City of Portland, Maine - Building or Use Permit

Permit No: 2013-00742		Date Applied For: 04/17/2013	CBL: 138 C016001
Location of Construction: 24 MAYLAND ST	Owner Name: PARADIS SHANA	Owner Address: 24 MAYLAND ST	Phone: (207) 776-2136
Business Name:	Contractor Name: self	Contractor Address: 24 Mayland Portland	Phone
Lessee/Buyer's Name	Phone:	Permit Type: Sheds

Proposed Use: Same: Single Family	Proposed Project Description: Construct detached Tool Shed 12' x 12'
---	--

2013-00742
138-C-16

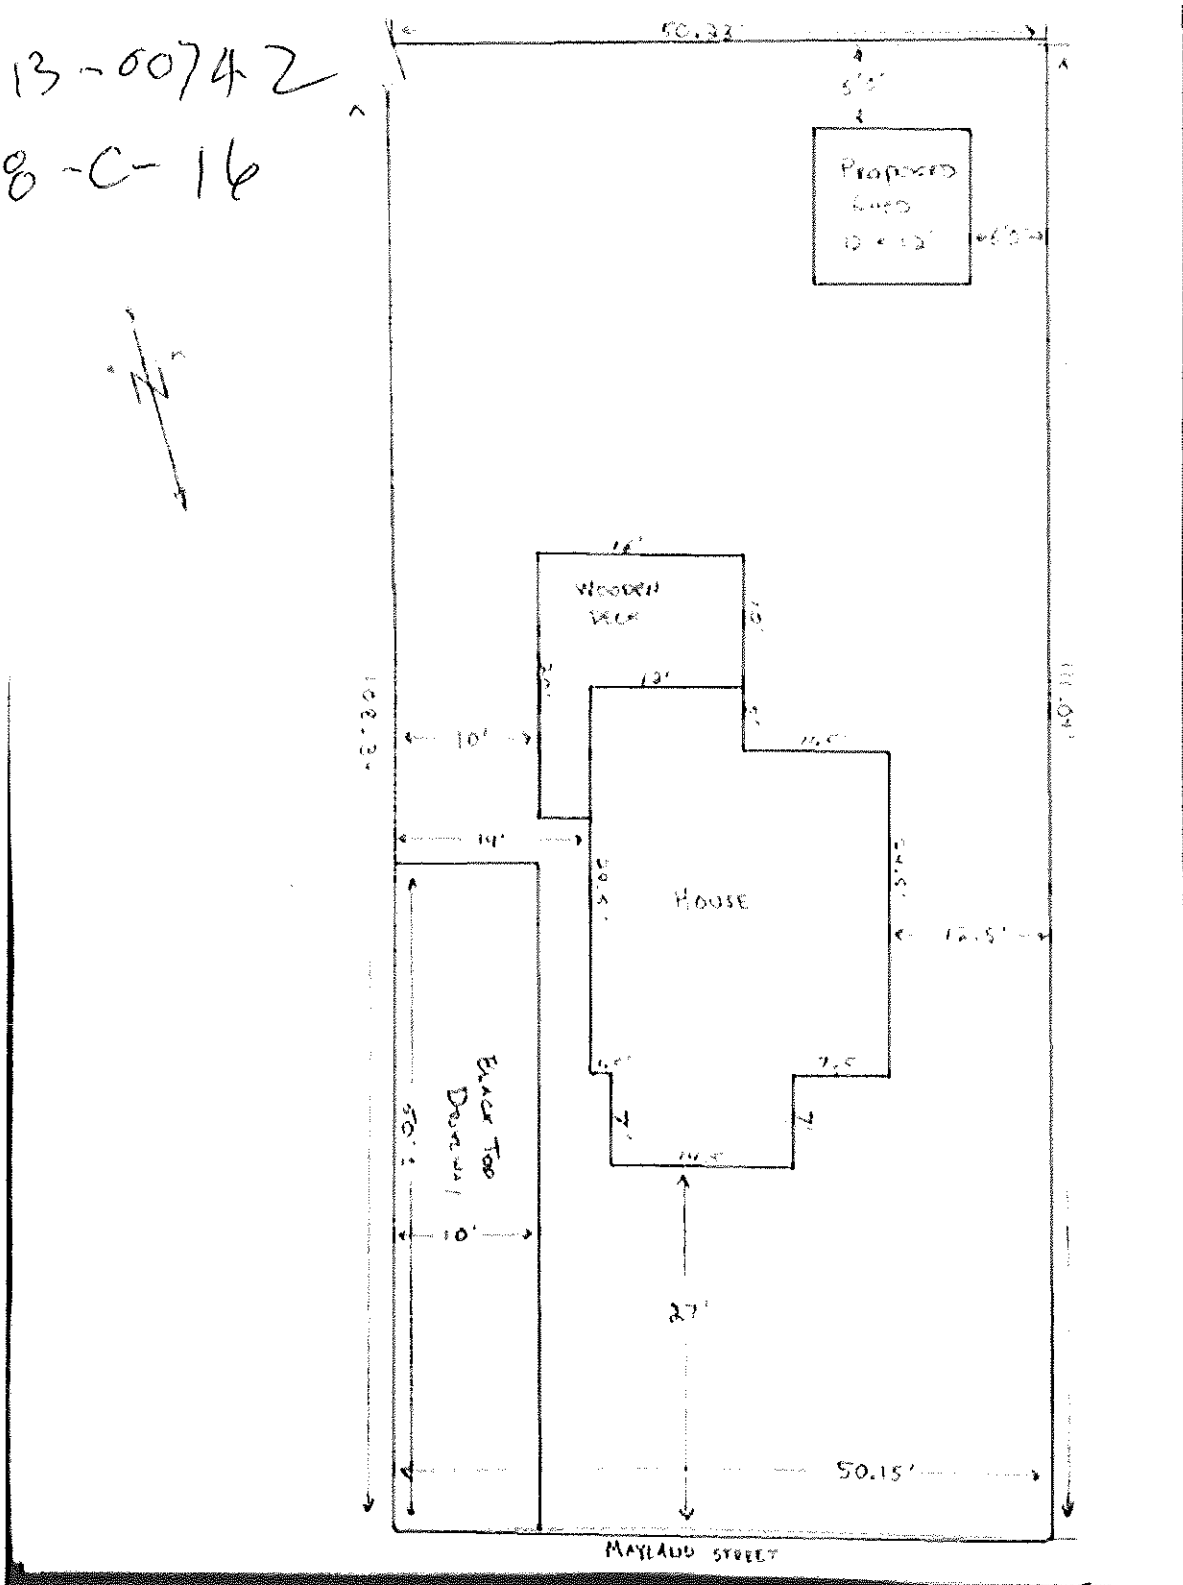
- 1) Property lines shall be strung prior to calling for a setback inspection for the shed.
- 2) Section R105.2 of the International Residential Code states that structures 200 square foot or under is exempt from building code review. This structure has not been reviewed for codes or safety under the Building Codes. The owner takes full responsibility for structural integrity.
- 3) This permit is being approved on the basis of revised plans submitted. Any deviations shall require a separate approval before starting that work.
- 4) This property shall remain a single family dwelling. Any change of use shall require a separate permit application for review and approval.
